Meeting Title: St Matthew's Catholic College – SSD submission review

Date: 13th August 2020

Note: Item references in meeting refer to meeting minutes between TSA and MWRC from 20/07/20.

DRAWING TITLE  
INTERSECTION UPGRADE PLAN -  
SHEET 1

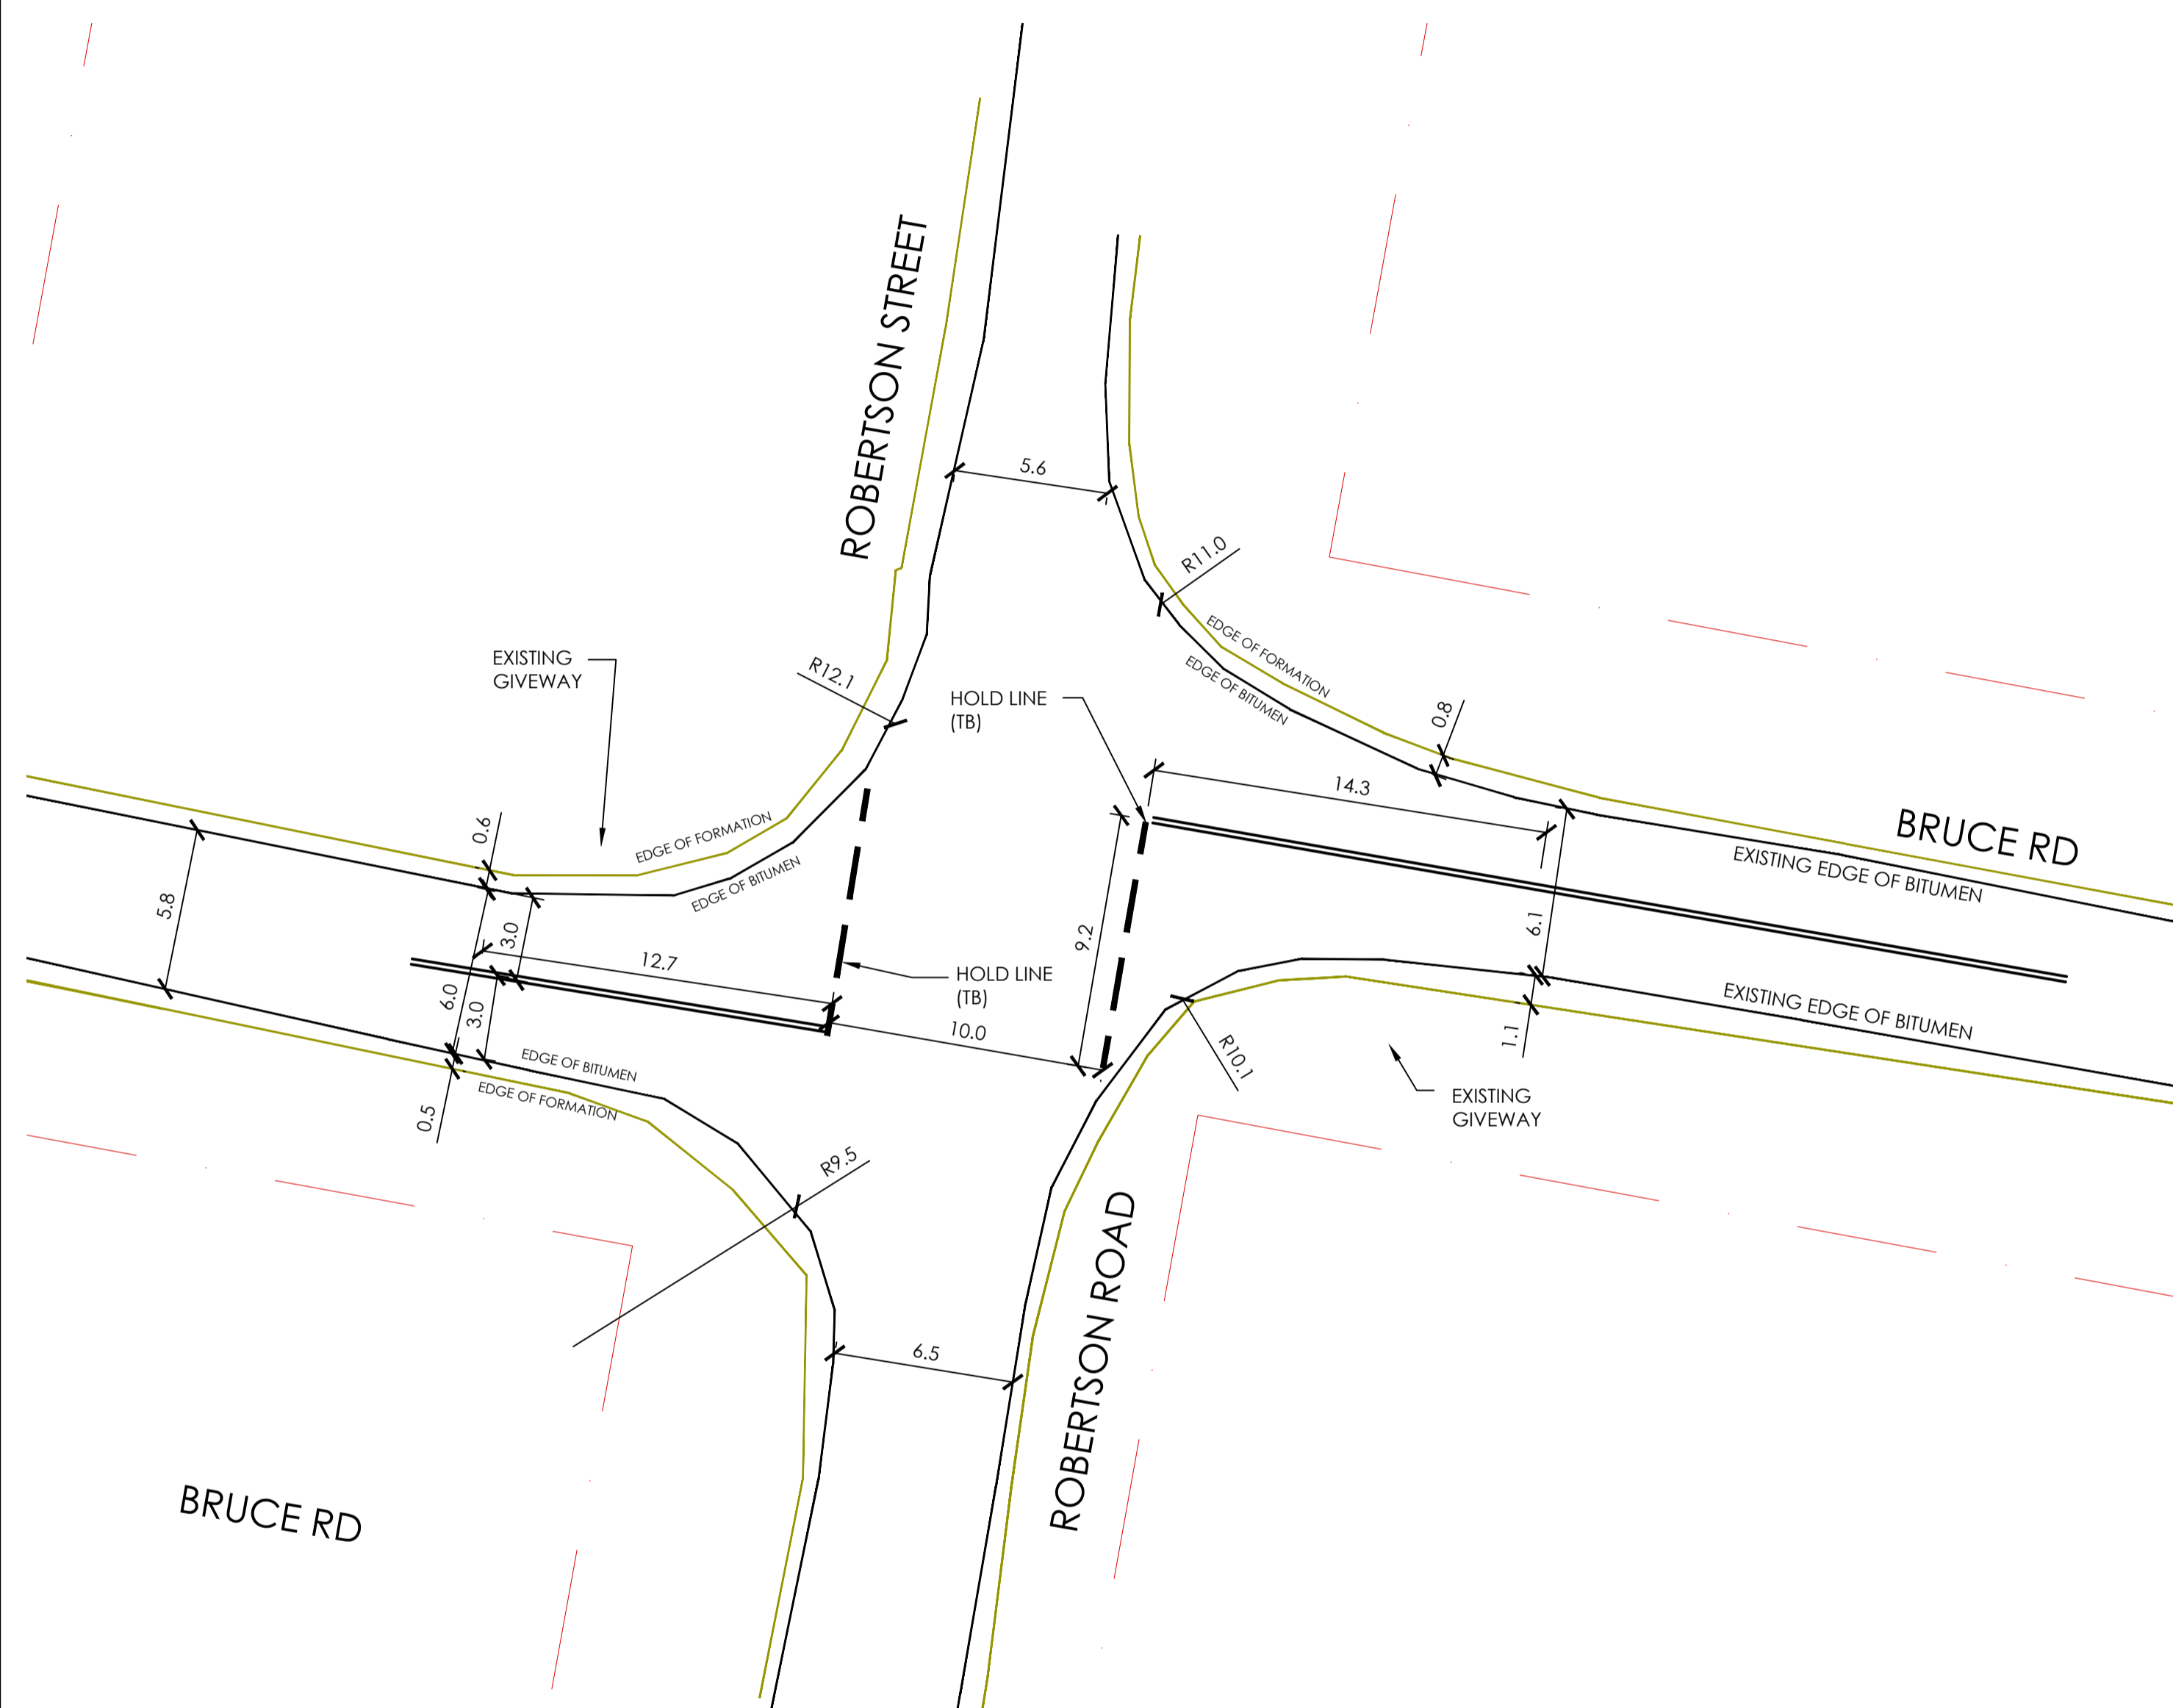
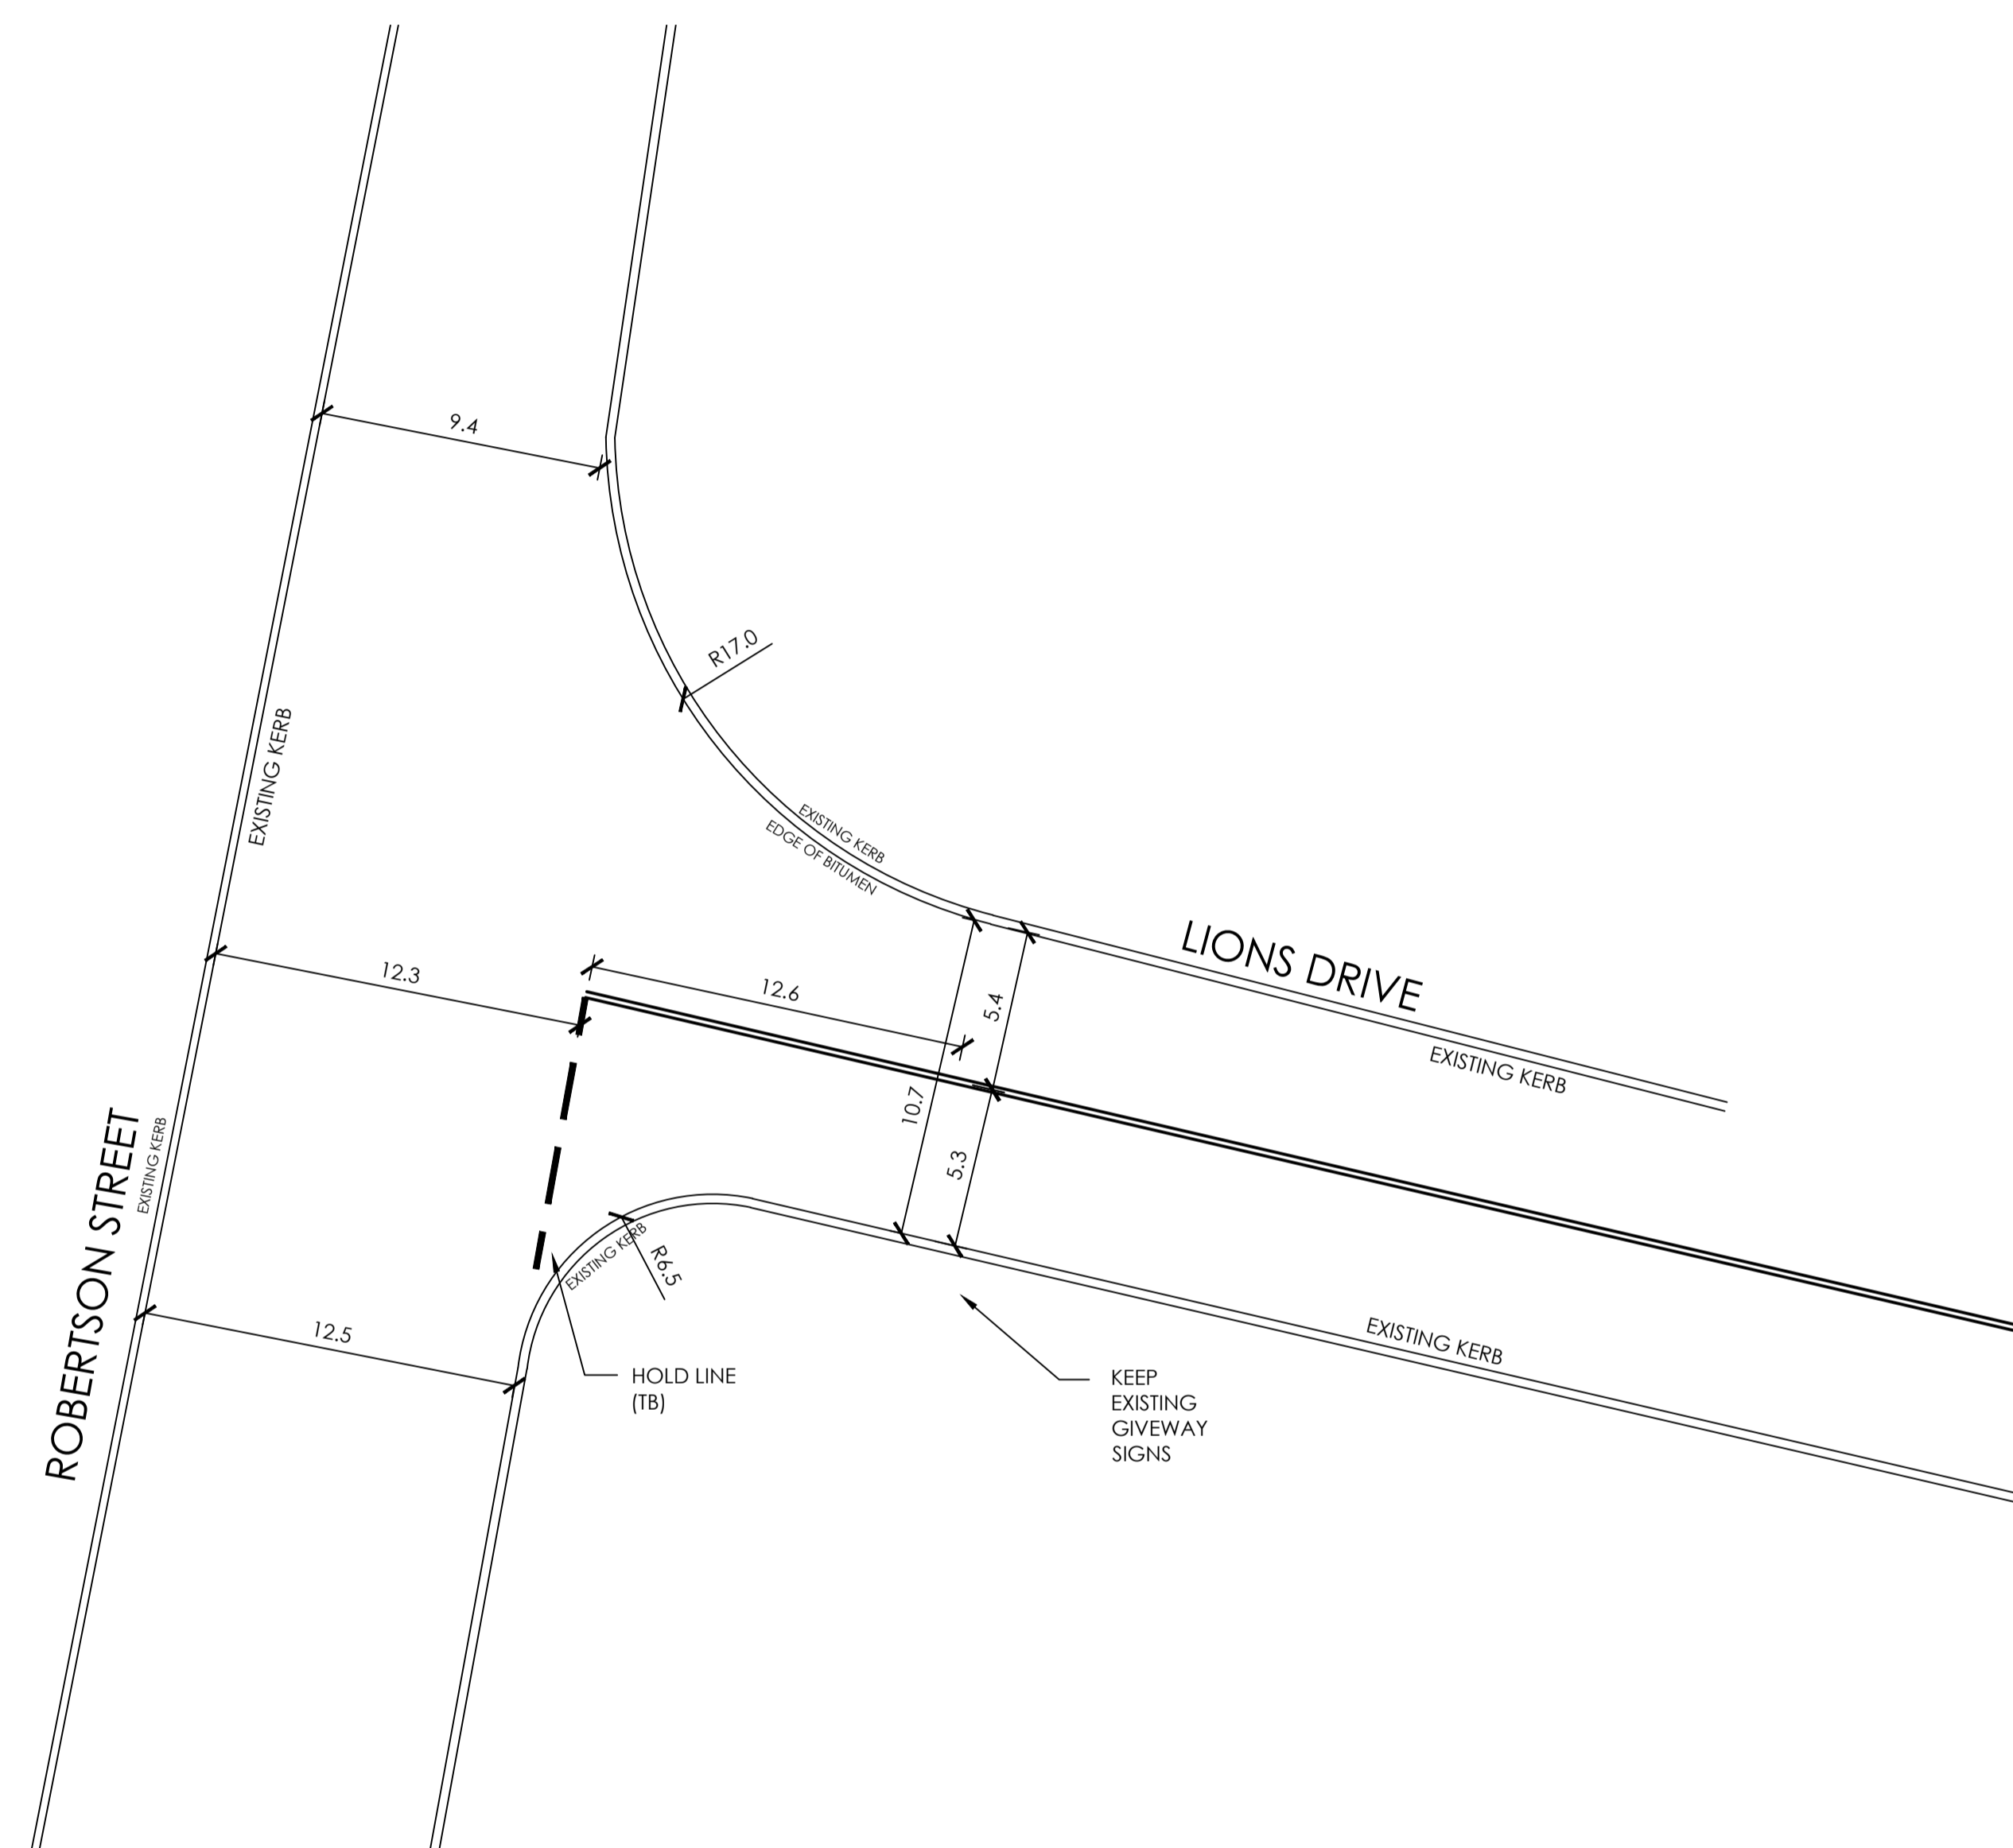
3.	<u>Upgrade of 4 Intersections (item 1.3.5)</u> The previous agreement to the upgrade of the Broadhead Road and Lions Drive along with the Broadhead Road and Bruce Road intersections was noted. All parties agreed that the remaining 2 intersections requested to be upgraded being Lions Drive and Robertson Road along with Bruce Road and Robertson Road intersections would be upgraded, for light traffic only, to service the school. CN to arrange additional studies and reviews to confirm the upgrades required.	Note CN	 21/8/20

BRUCE ROAD BUS TURNING BAY

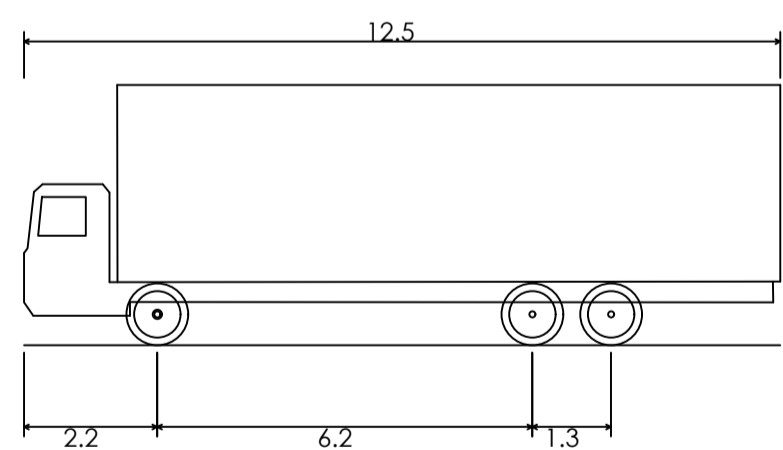
4.	<u>Bruce Road Upgrade (item 1.3.3)</u> CEDP will provide an update construction traffic management plan in the response to submissions, noting that construction traffic will not travel along Bruce Road. All agreed that the upgrade to Bruce Road is not required as it is not being used for Construction traffic. Council request updated Construction Traffic Management Plan include construction traffic forecast. CN agreed to provide.	CN Note CN	 -
